Please treat the attached planning statement as substitute and scan the e-mail against the application as additional info from agent

Dear Anita Gardner, thank you for your response to this application, I set out below my response to the items raised:

SCALE / 1:100 @ A3
DATE / 22.03.2017
DWG. NO / 080616 / TP.02 'A'

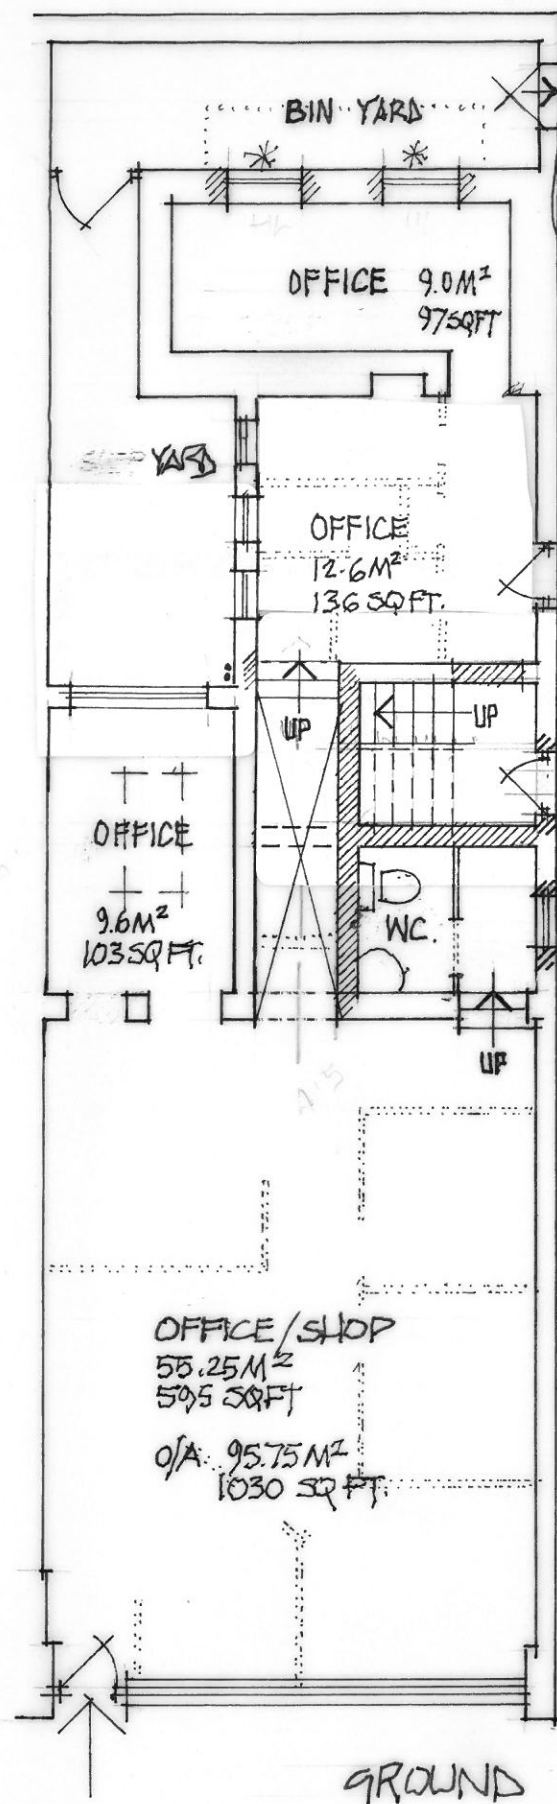
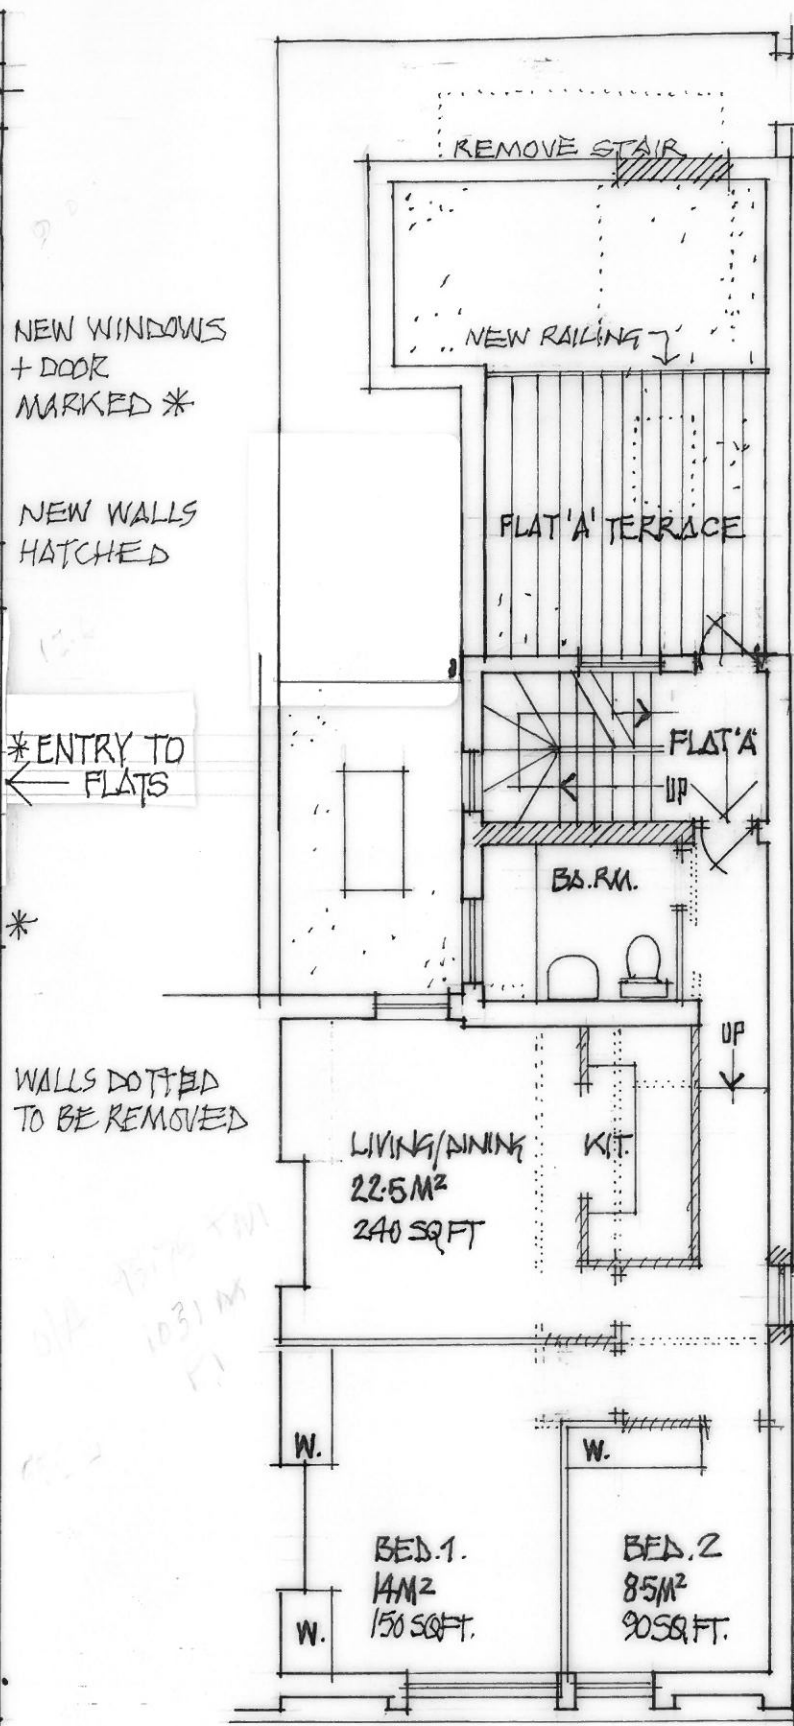
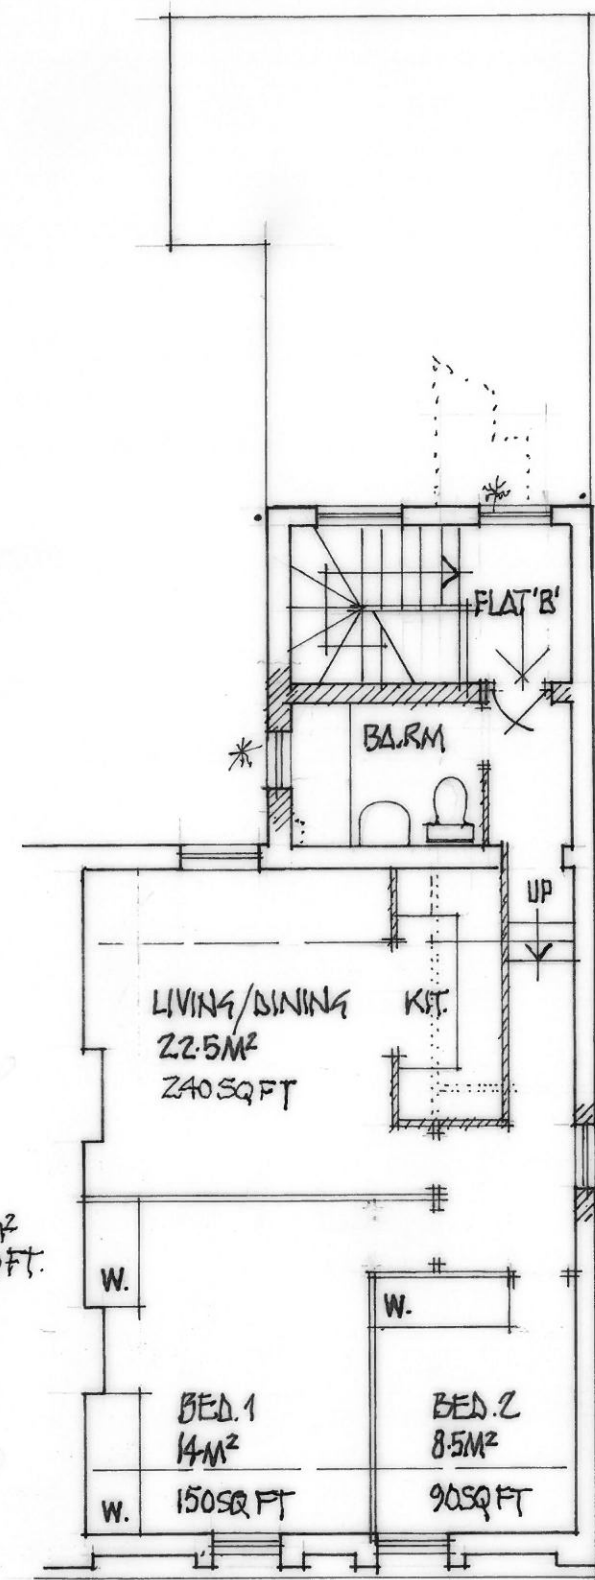
- 1) There are areas on the first and second floors where the letter "W" is written. What does this mean? Wall?
- 2) The applicant has proposed to site the entrance door to the internal communal staircase, located at ground floor level in the entrance road to Manor Car Park. The road itself is rather narrow and to have a residential doorway opening onto it would seem unsafe without a paved/guarded area to exit/enter onto. My thoughts are that perhaps keeping the external stairs would be a safer option, but I appreciate Flat A wouldn't then have exclusive access to the roof terrace.

- 3) There is no mention of a fire alarm system and what fire-resisting separation there is between the commercial and domestic areas.
- 4) Internal doors are not annotated on the plans supplied for the flats.

- 5) Railings to the Flat A roof terrace have been proposed, but no detail of height and type have been provided.

1. The letter 'W' on the plans indicates a wardrobe.
2. I attach a revised version of the Planning Statement with a new item 12 stating that of course all Building Regulations will be complied with and consent obtained. Details will form part of the future Building Regulations application.

3. The existing side access to the offices and the rear yard gate both open onto the vehicle access at the side of the property. The door is slightly relocated but the same situation is retained. Currently office staff numbers are approximately the same as will be the case when the new residential use is established. The door and gate both open inwards which is normal and does mean that egress is slowed down due to the action of opening them before stepping out. We could apply for permission the place a bollard each side of the door but this may require Arun D C consent. [See attached sketch]
